RE: **PAVING PLAN** – 4010 Central Ave. SW  
**Grading Plan** for Paving Permit

# **K12-D033**  
PE Stamp: 9/13/2013

Based upon the information provided in your submittal received on 10/3/13, the above referenced Grading Plan cannot be approved for Paving Permit, until the following concerns are addressed:

A PROPOSED
PAVING PLAN
FOR
4010 CENTRAL AVENUE S.W.
ALBUQUERQUE, NEW MEXICO
AUGUST, 2013

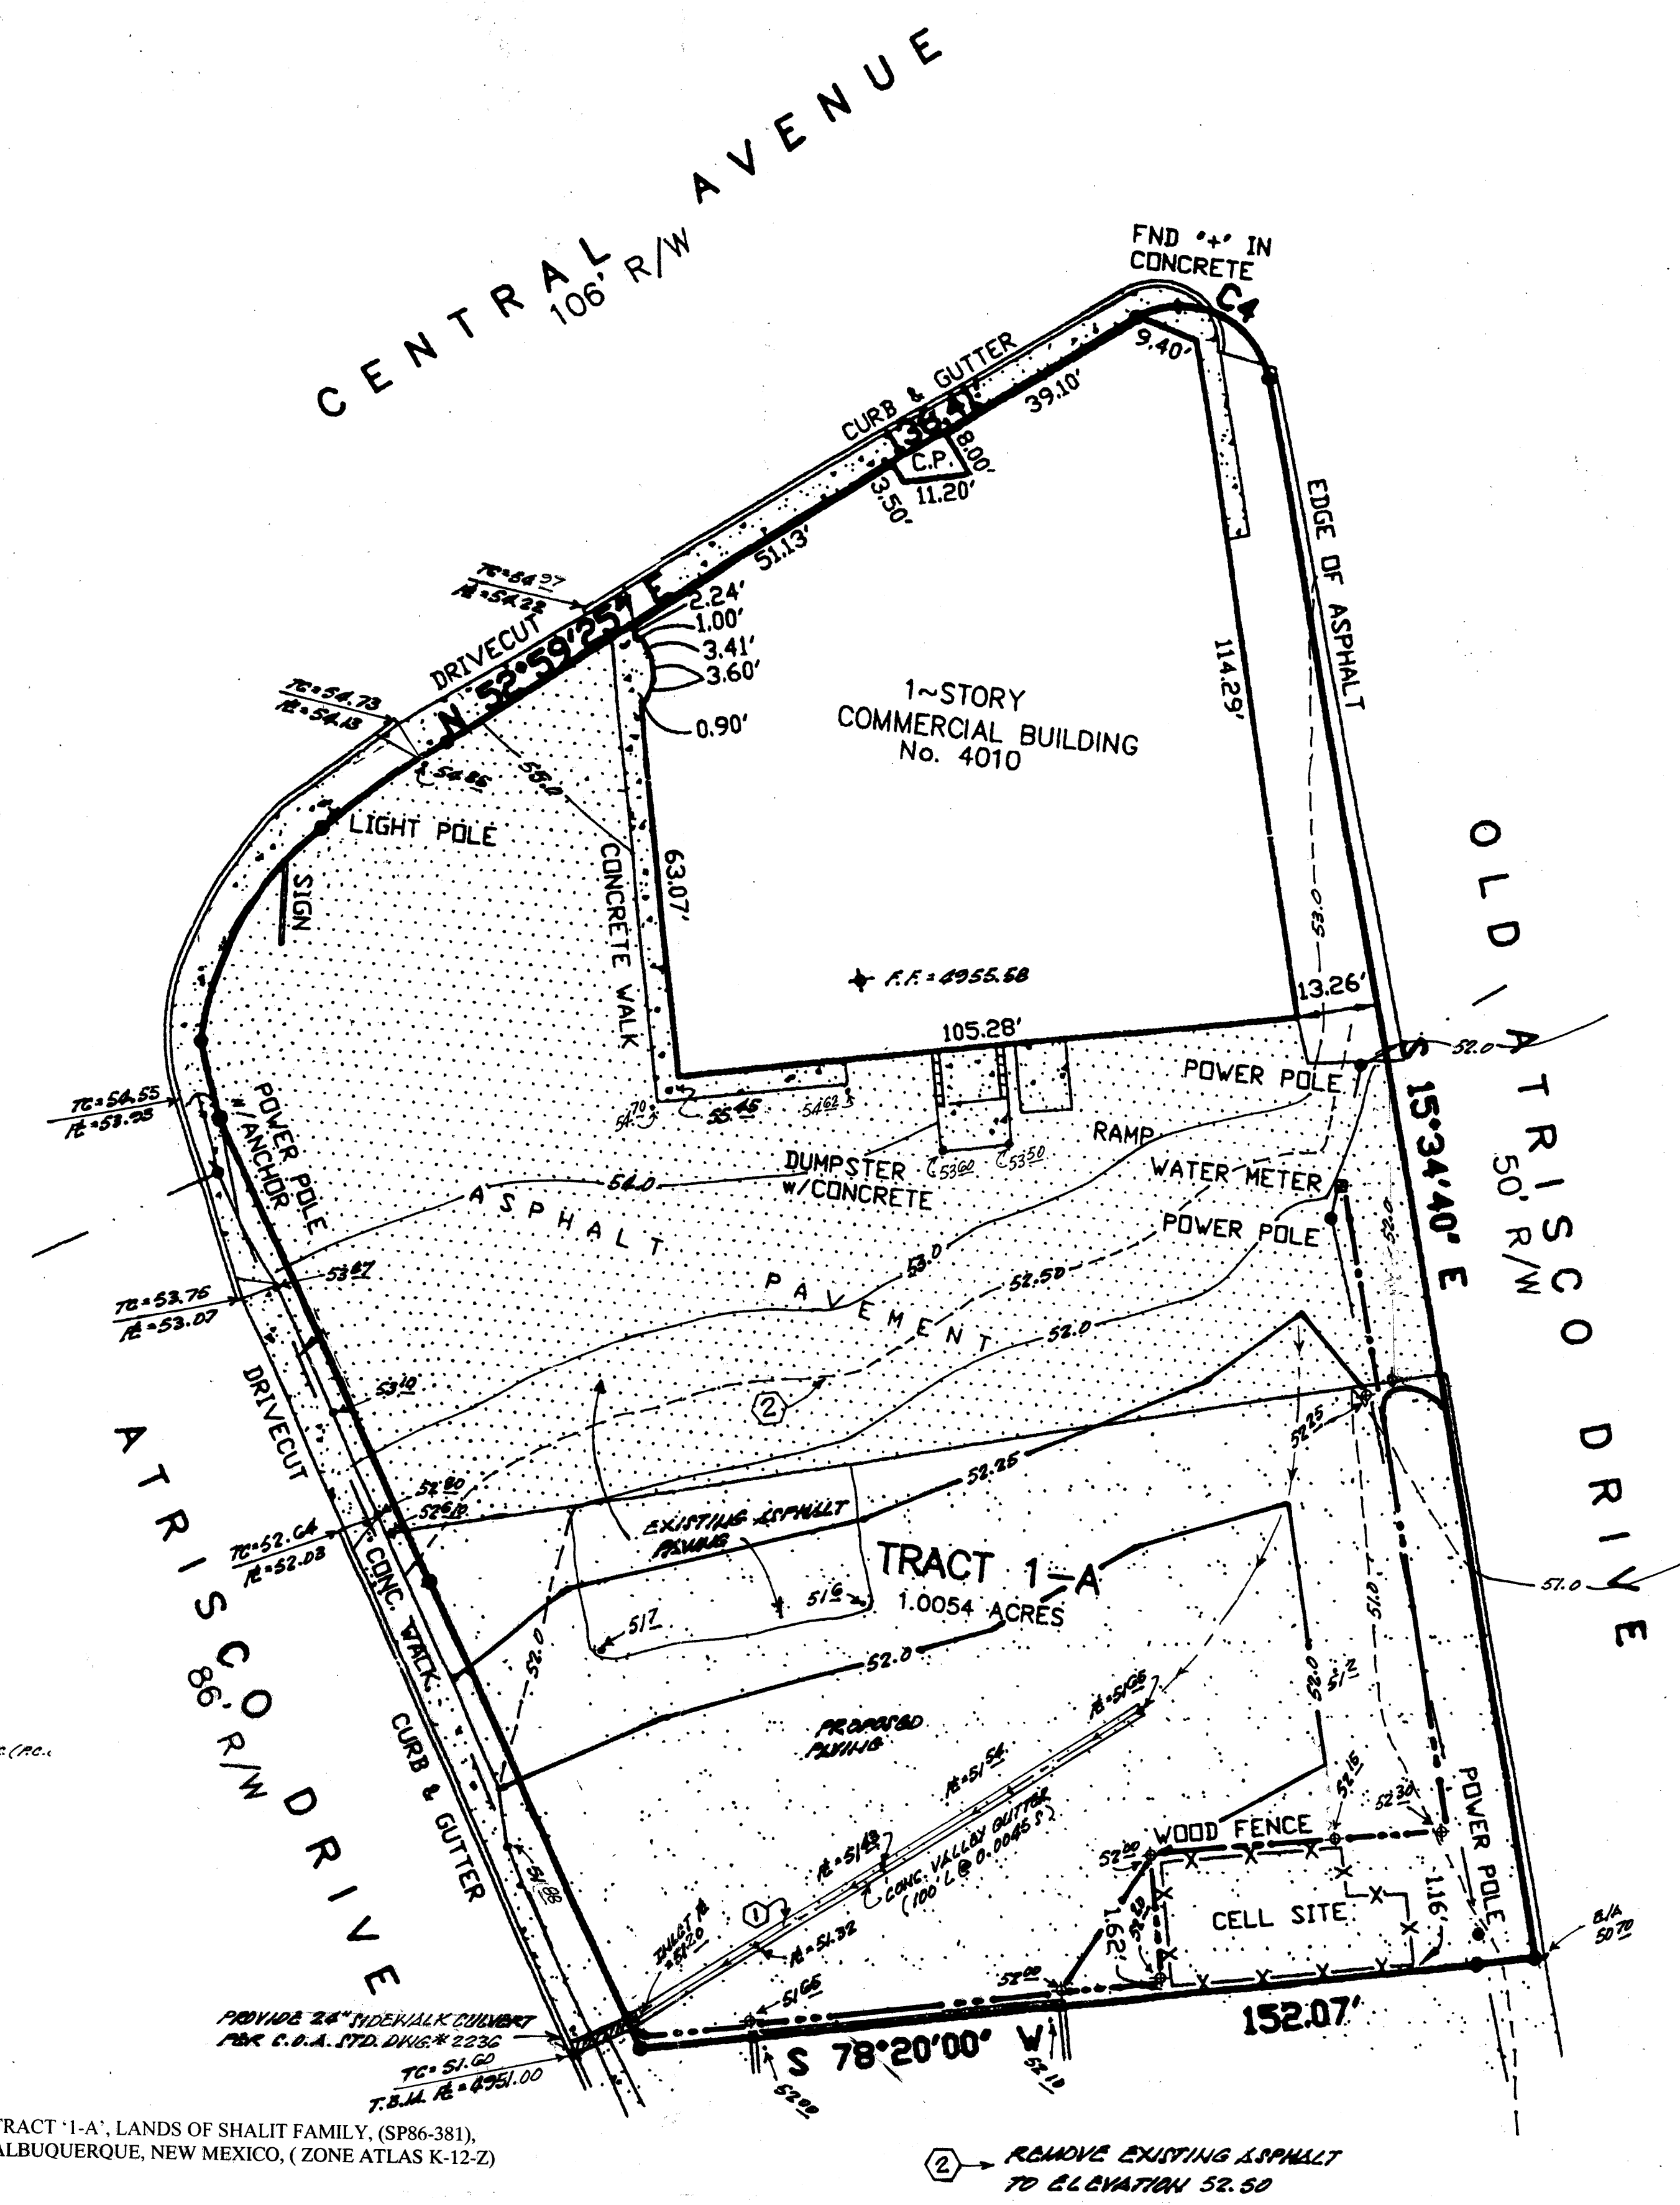
1. Clarify grades in the area around the cell tower site (SE corner). There seem to be some large grade changes in that area. Identify the grade break north of the tower, and provide flow arrows to show where flow is intended to go.
2. Label the proposed asphalt curb and clarify whether there is paving between the curb and existing pavement on "Old Atrisco Road." Provide some flow
3. Revise grades in the paved area and create a landscape buffer to serve as a water harvesting pond along the south edge of the site, between the cell tower and the new sidewalk culvert, to reduce the developed runoff to nearer the existing rate.
4. Update SO-19 details per current details emailed to George Rodriguez on 10/30/13.
